**KIRKLEES METROPOLITAN COUNCIL
INVESTMENT & REGENERATION SERVICE**

**DELEGATED DECISION FOR APPLICATION FOR CERTIFICATE OF
LAWFUL DEVELOPMENT**

Reference no.: 2024/CL/92141/W

Site: 26, Thackeray Grove, Crosland Moor,
Huddersfield, HD4 5HD

| Drawing Title: Proposed Grouped Plans | |

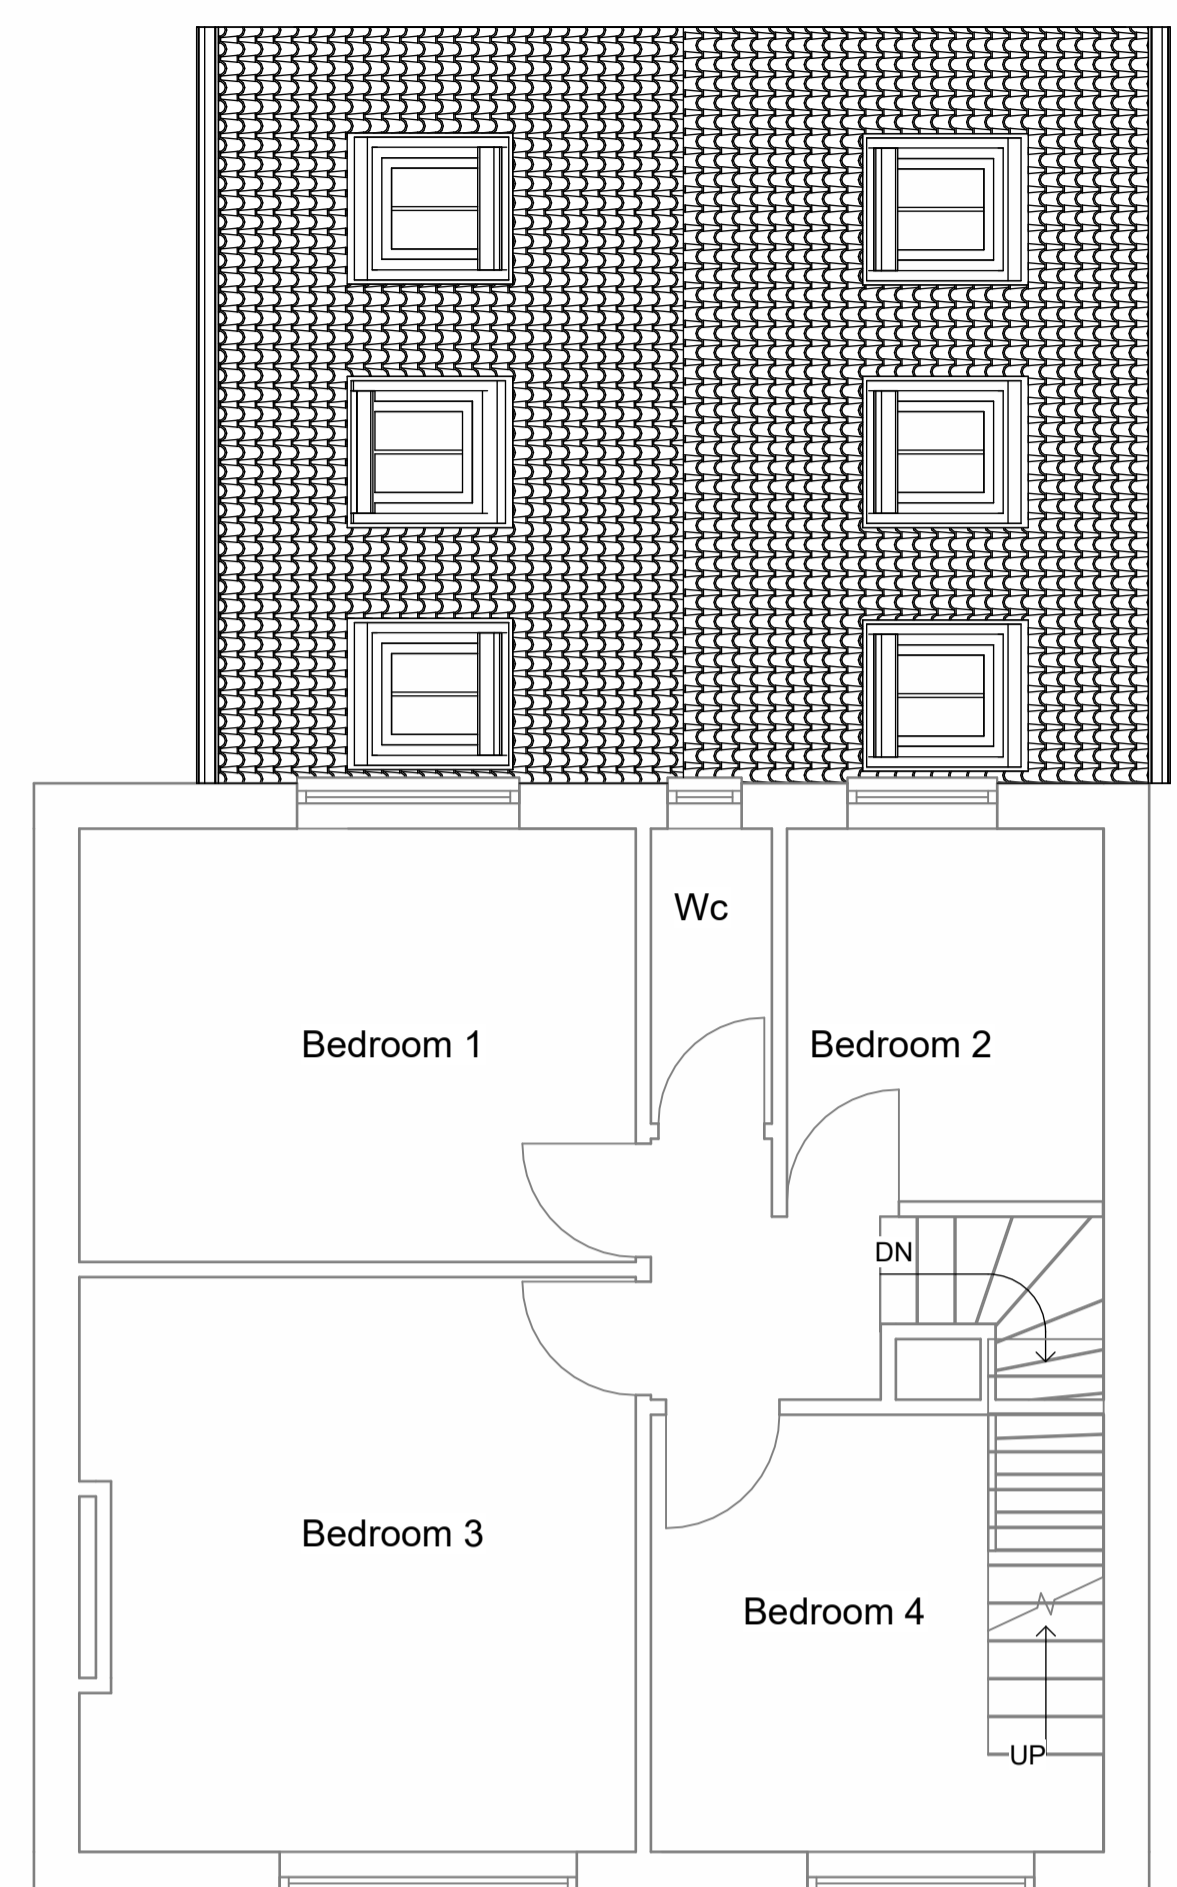
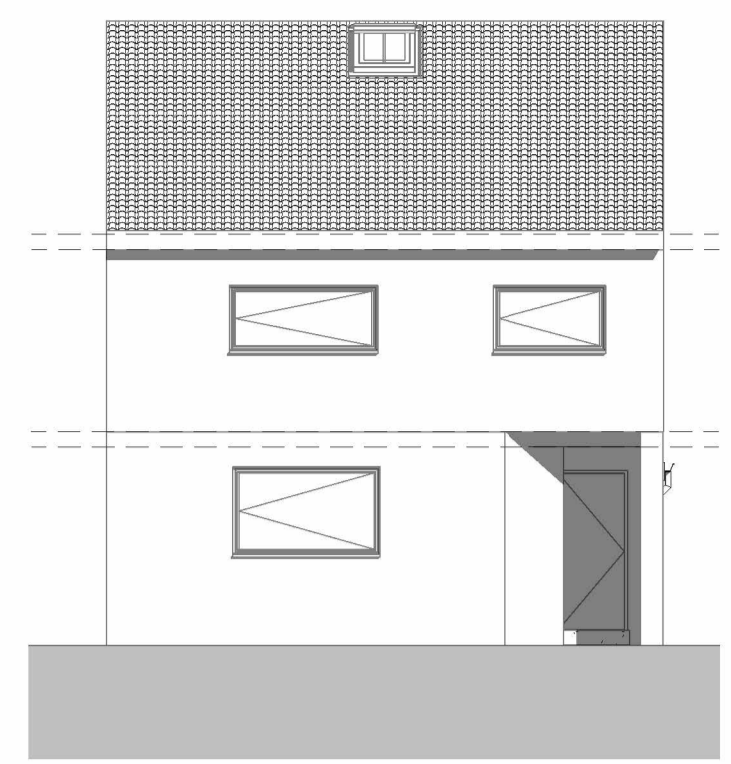
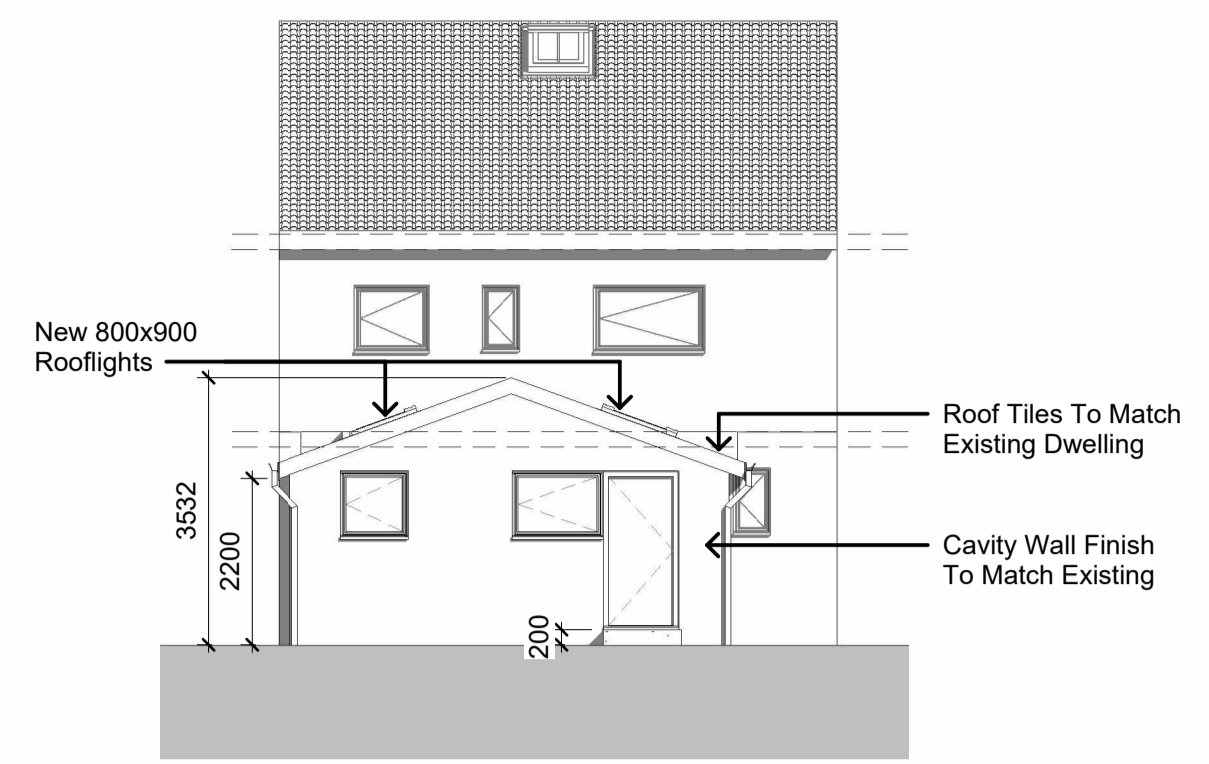
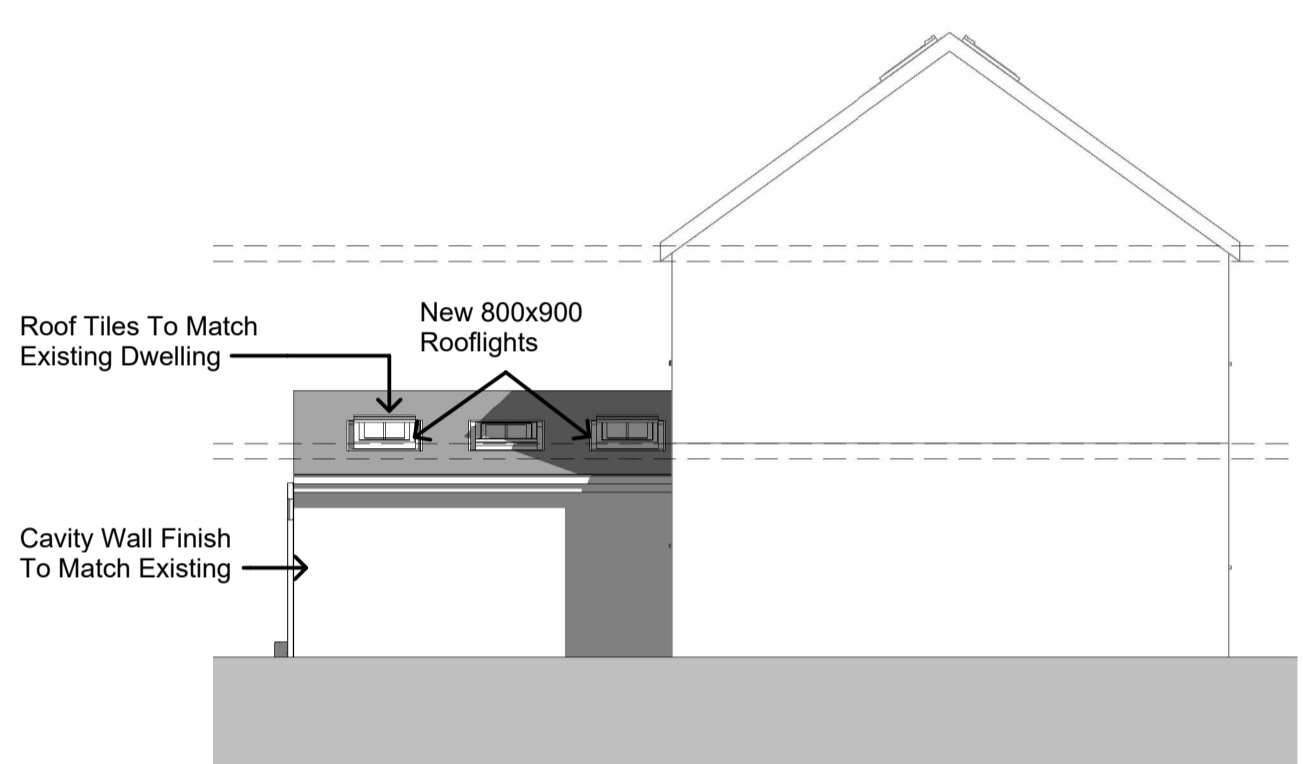
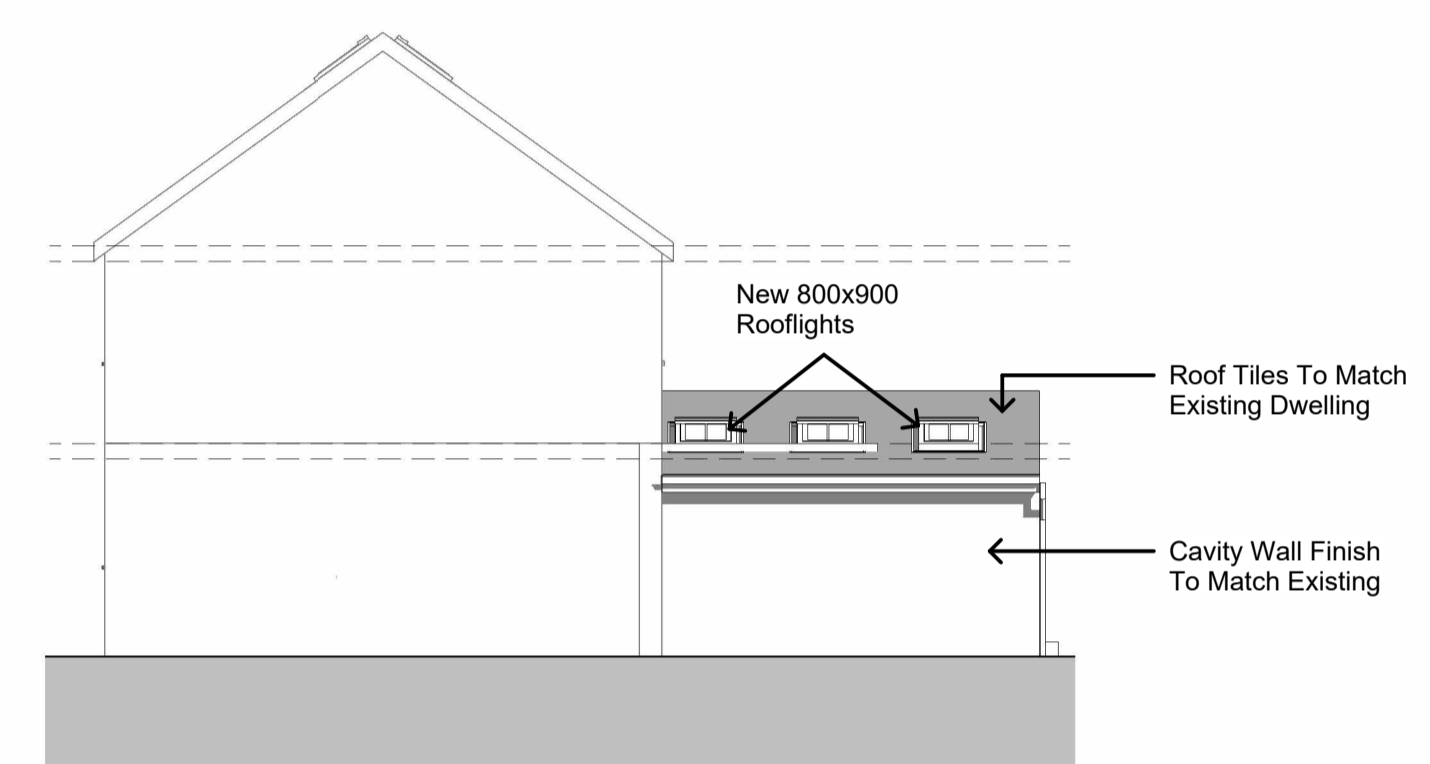
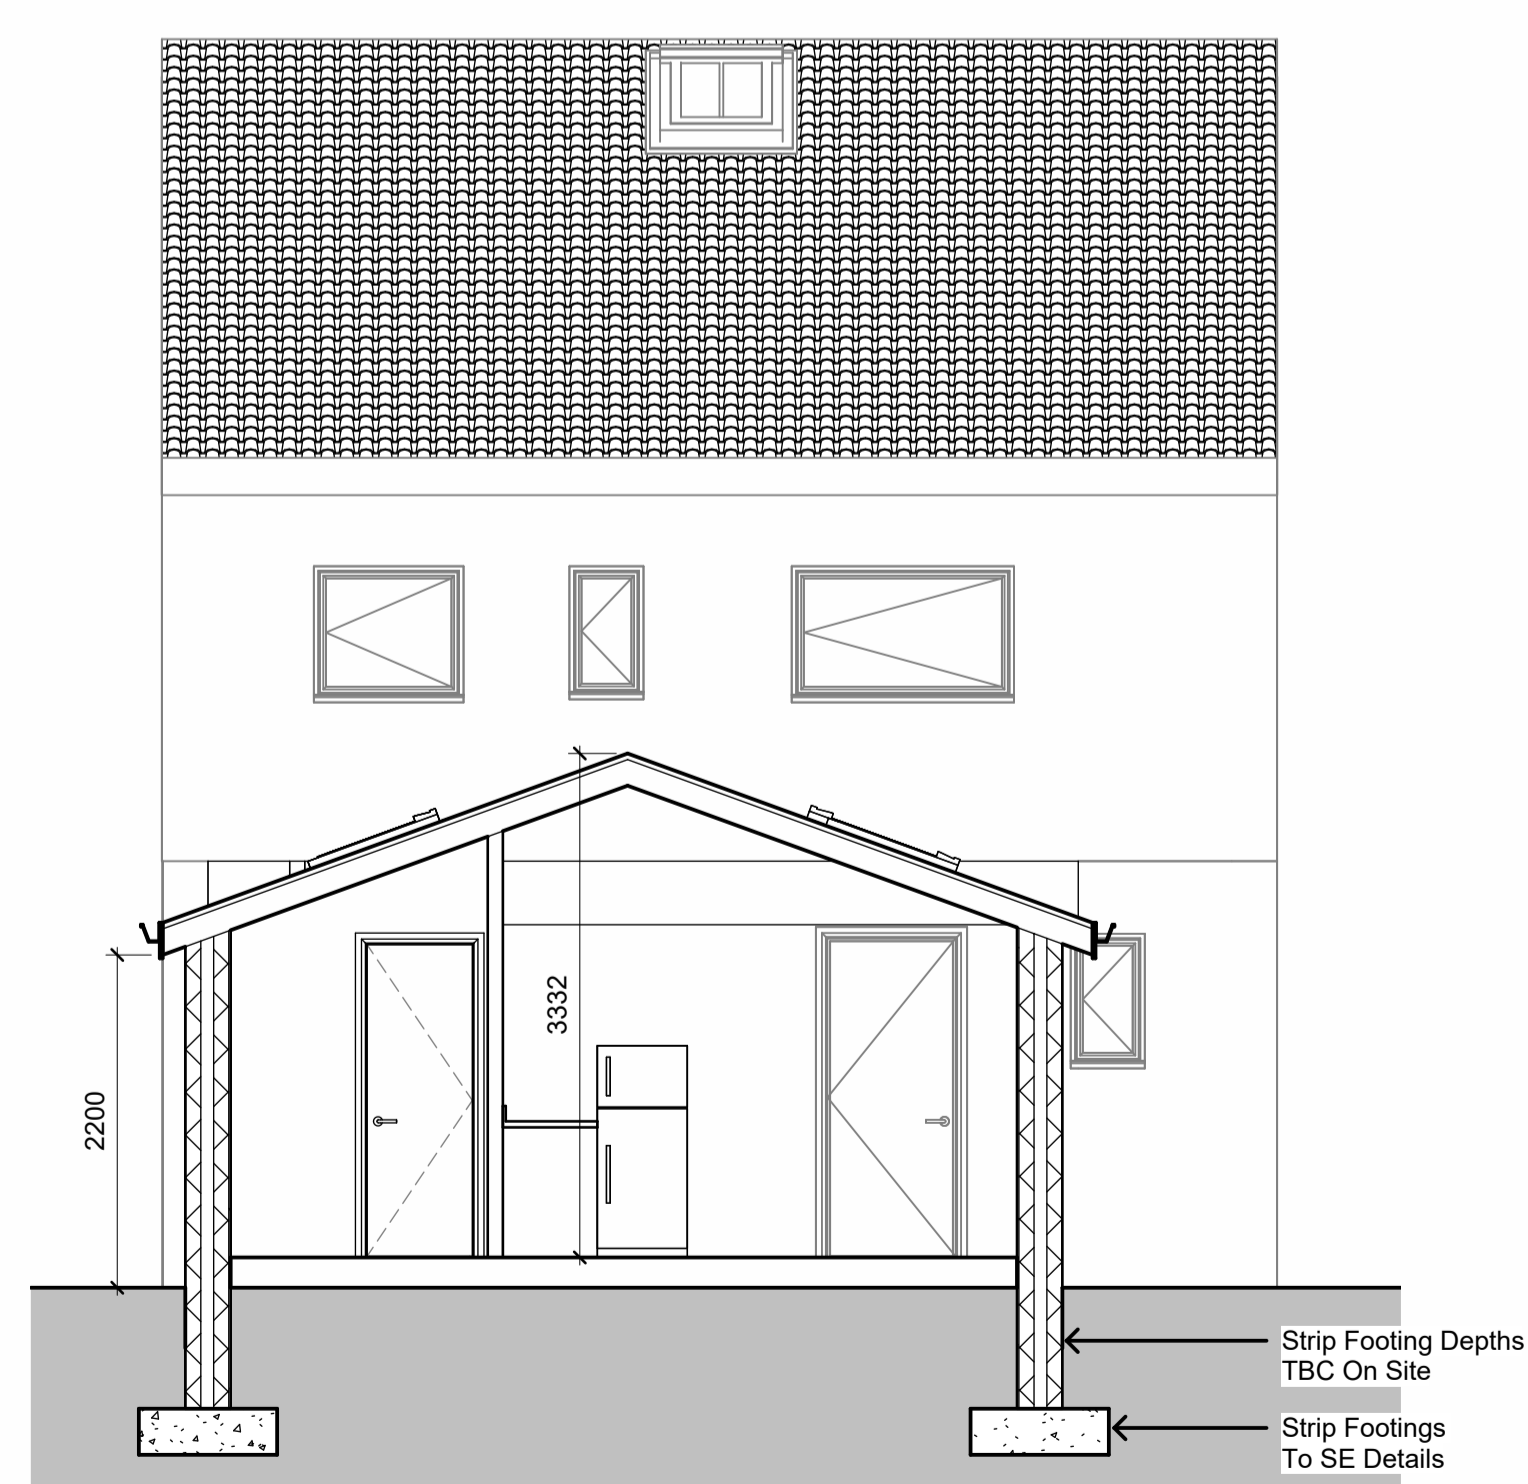
The extension would measure 5000mm projecting, 5800mm wide and have a total height of 3532mm. The height to the eaves would be 2200mm. Materials used in the construction are to match the existing.

Comment: *The enlarged part of the dwellinghouse would be single-storey and would extend beyond the rear wall of the original dwellinghouse by more than 3 metres although would not exceed 4 metres in height however considering the dwellinghouse is not on article 2(3) land nor on a site of special scientific interest, paragraph g) thresholds apply.*

Comment: *The enlarged part of the dwellinghouse would be single-storey and would not extend beyond the rear wall of the original dwellinghouse by more than 6 metres and would not exceed 4 metres in height*

Comment: *The enlarged part of the dwellinghouse would be within 2 metres of the boundary of the curtilage and the height of the eaves of the enlarged part does not exceed 3 metres.*

Paragraph A.4 of Class A imposes a condition where the proposed development exceeds the limits in paragraph A.1(f) but is allowed by paragraph A.1(g), as is the case in this instance, the developer must provide further details before the development commences. Moreover, the development must also not commence until the Local Planning Authority has either given written notice that prior approval is not required, prior approved is given or neither event has occurred before the expire of 42 days following the date the information was received.

In this instance, no further details have been provided for the Local Planning Authority to consider whether prior approval should be given or is not required and as such condition A.4 has not been discharged.

exception, limitation or condition specified in Schedule 2. In this instance, if the development was begun at the time of this application, condition A.4 of Class A has not been complied with and thus cannot be considered lawful by reason of article 3(2).

The proposed single-storey rear extension if begun at the time of the application would not benefit from a general planning permission granted under Article 3(1) and Schedule 2, Part 1, Class A of the Town and Country Planning (General Permitted Development) (England) Order 2015 (as amended) as it would fail to comply with condition A.4 of Class A.
